CITY OF ALBUQUERQUE

April 27, 2023

**Re: Insight Cabinet Shop
2017 Ridgecrest Dr. SE
30-Day Temporary Certificate of Occupancy
Transportation Development Final Inspection
Engineer's Stamp dated 05-17-21 (G14-D096)
Certification dated 11-02-22**

**C100**

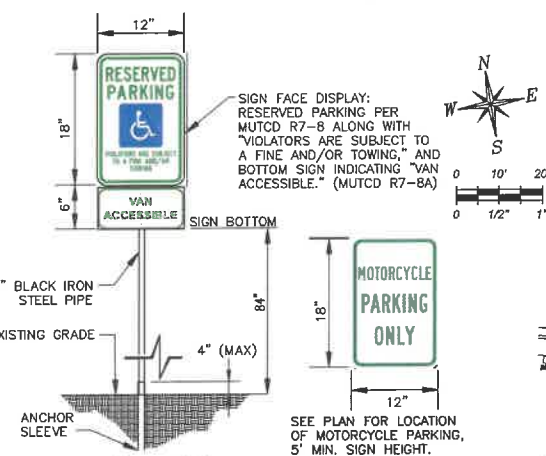
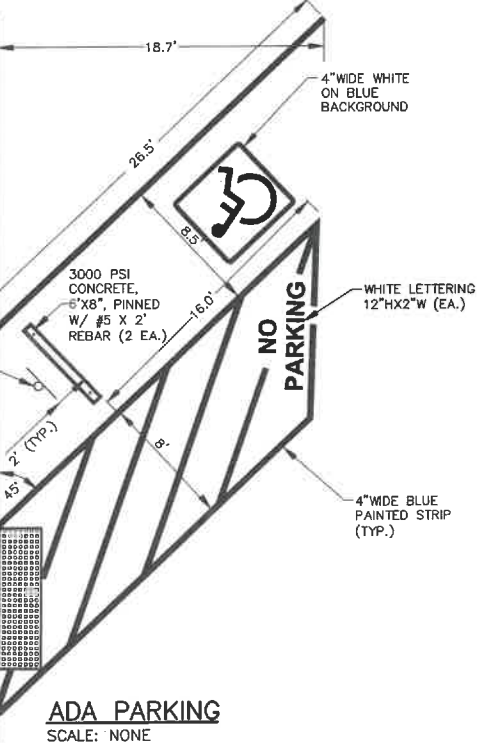
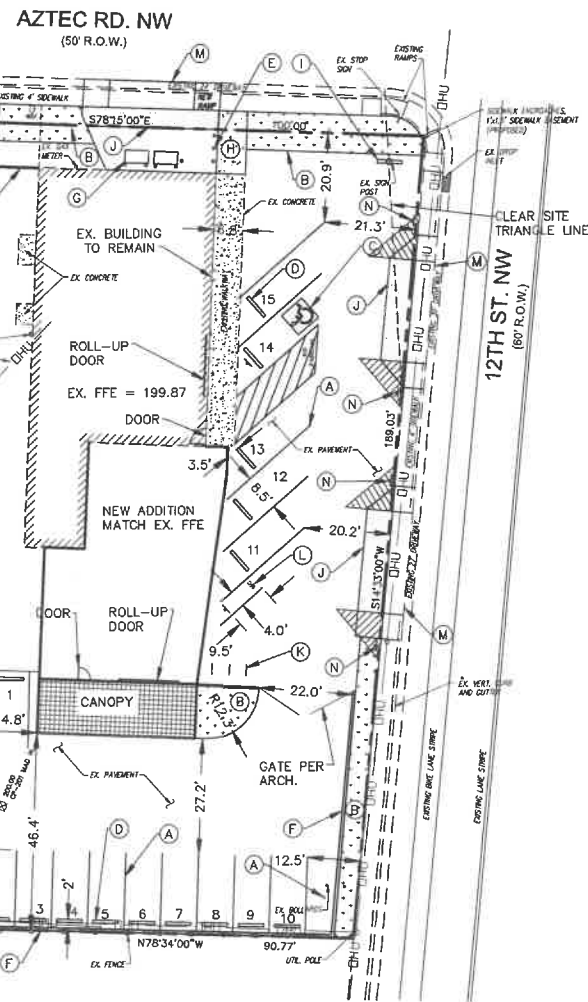
- Per approved site plan, please install concrete parking bumpers in each parking space.
- Key note N: Please provide directions signage for the site driveway accesses, as mentioned on the approved site plan keynote N.
